**From:** Elizabeth Killey  
**Sent:** 26 July 2016 15:48  
**To:** Robert Arguile  
**Subject:** FW: 6/2016/0616/FULL 2 De Havilland Close, Hatfield, AL10 0DR Conversion of dwellinghouse into 2no dwellinghouses

The Private Sector Housing Team have no specific objections to the application. However, it is necessary to comment on the proposed layout of the First Floor in the 'HMO' property.

PROPOSED FIRST FLOOR PLAN

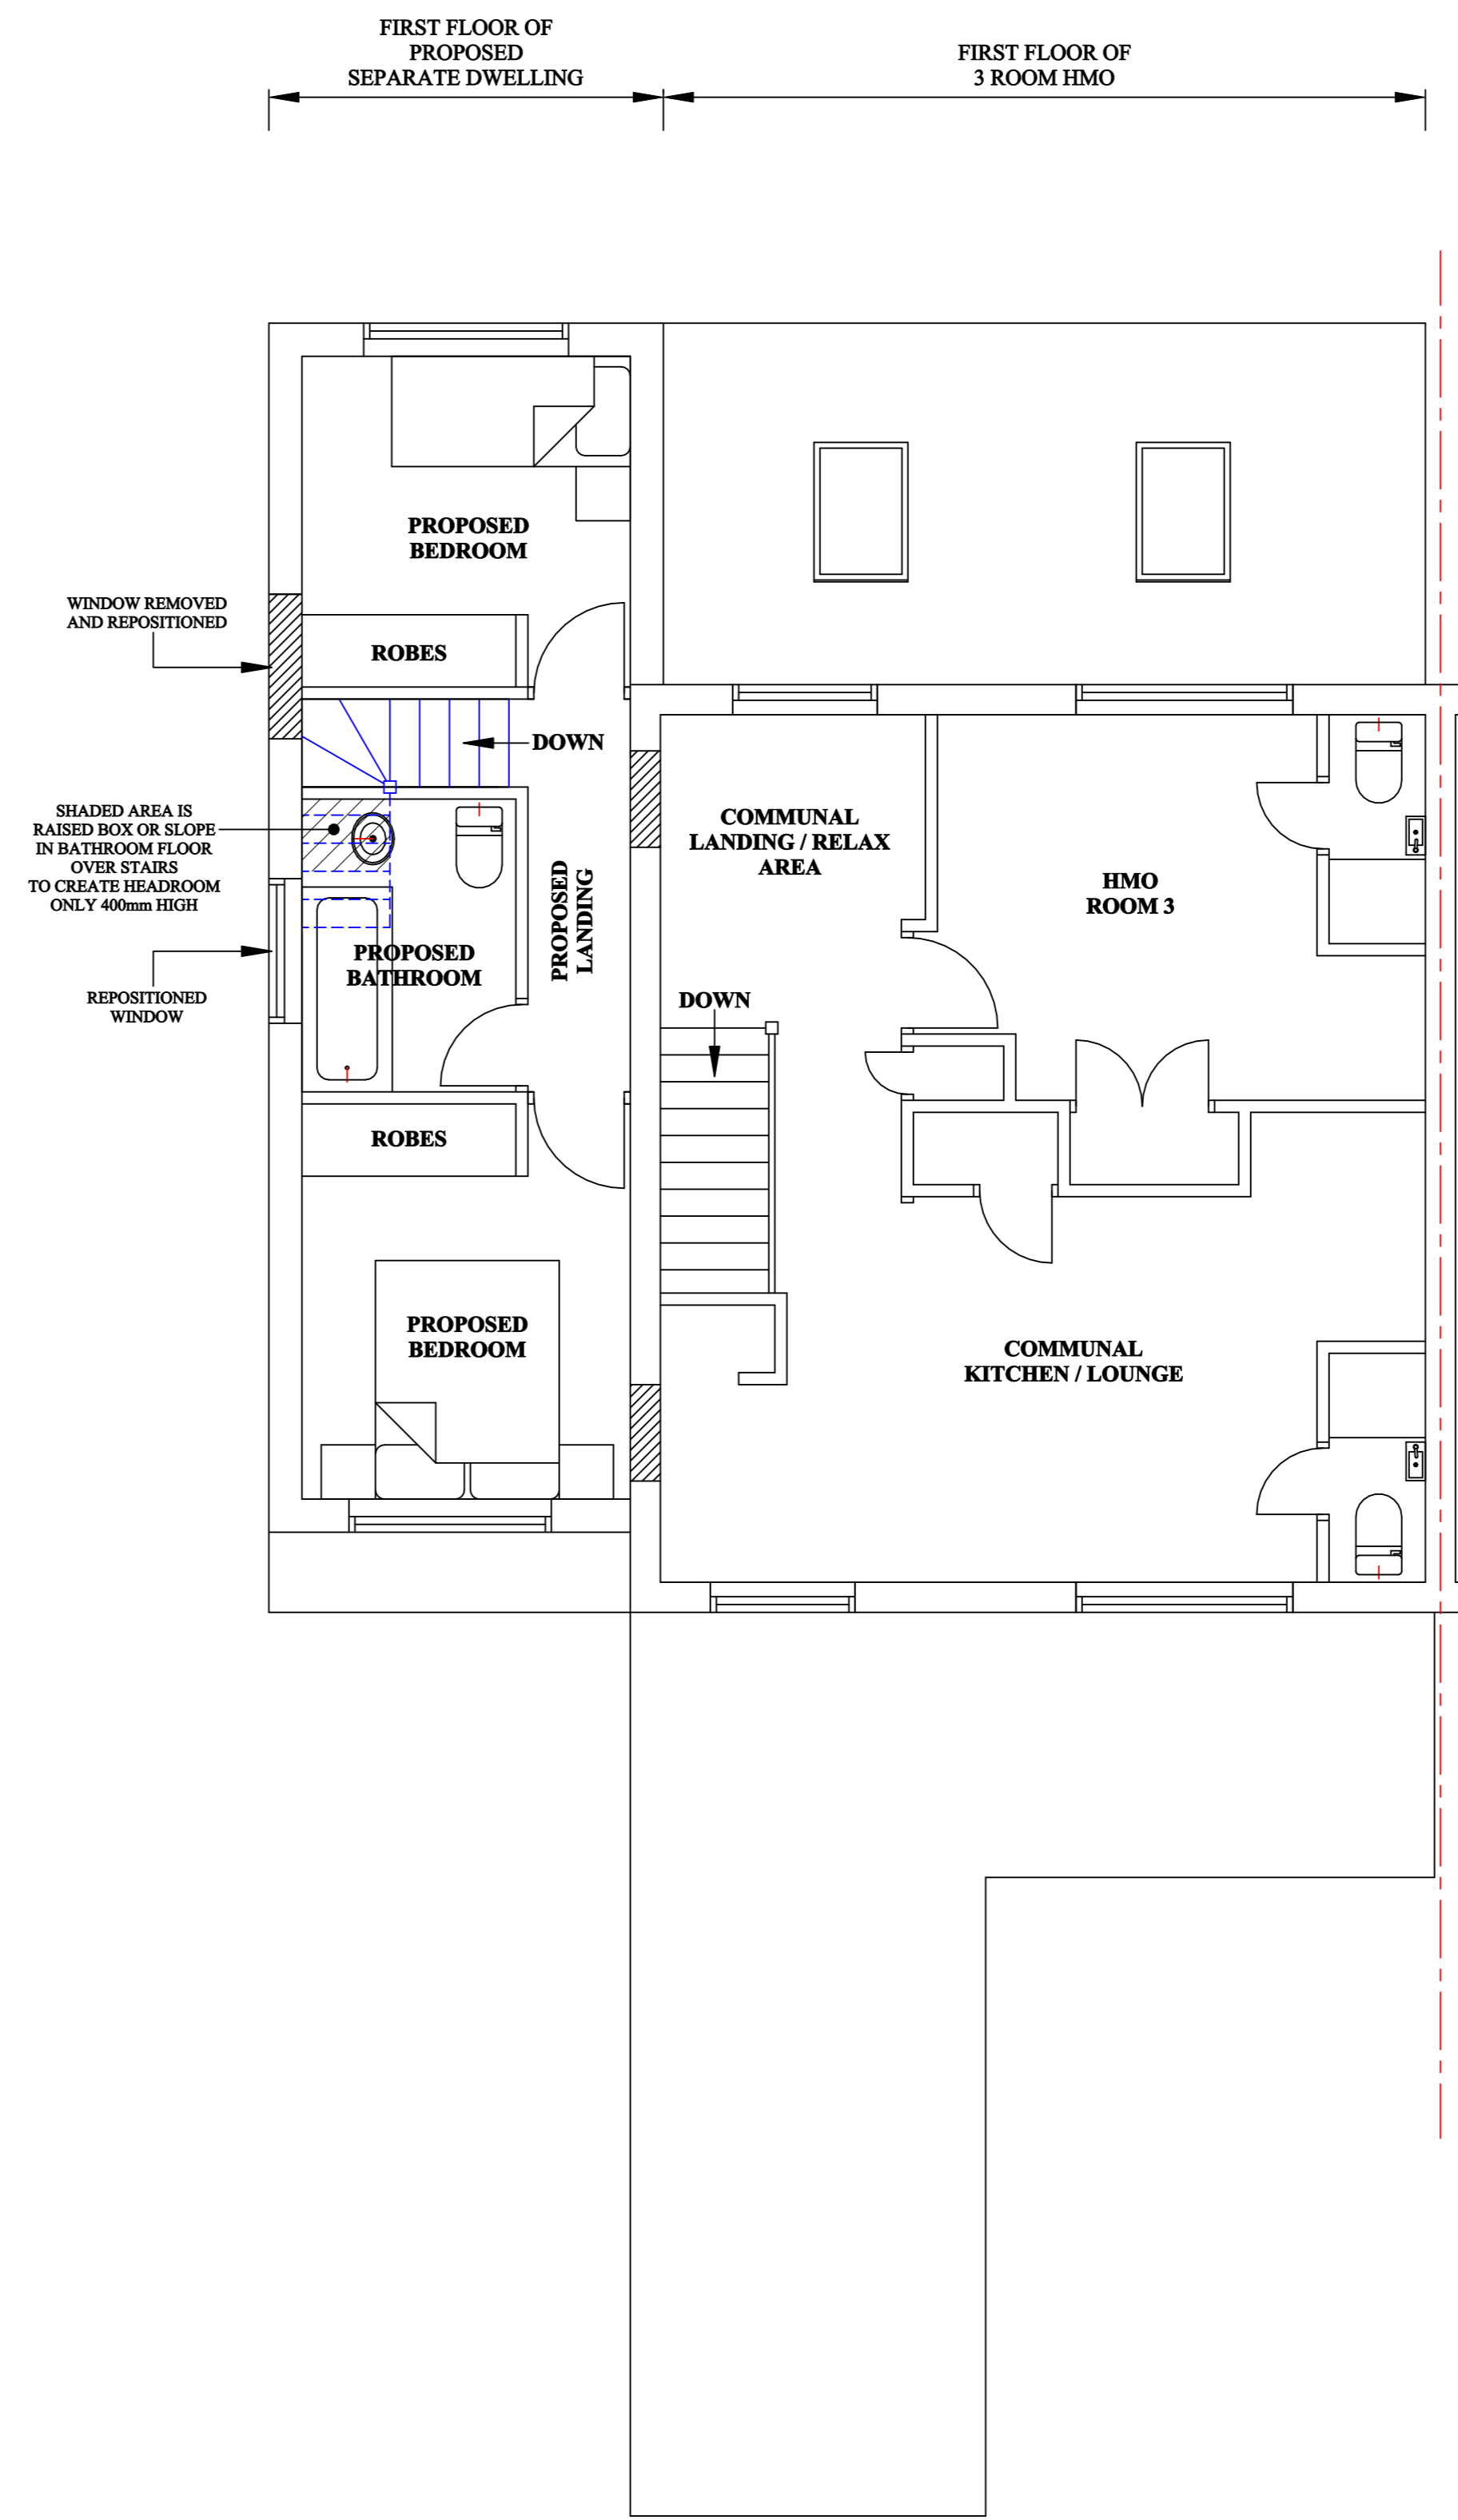
The plan shows the staircase open to both a communal landing/relax area as well as to the main communal kitchen and lounge.

In HMOs, the staircase must be protected with a minimum of 30 minutes fire resistance from all risk rooms (e.g. kitchens, living rooms & bedrooms) in order that it can provide a safe means of escape. Therefore the current arrangement would not be acceptable.

Also, it is unclear where the exact location of the kitchen will be and I note that there is a communal shower room opening into the kitchen/lounge area. Shower rooms and toilets opening directly onto kitchens do not promote good food hygiene practices. Ideally, this shower room should be relocated or as a minimum located so that it opens into the lounge area of the room.
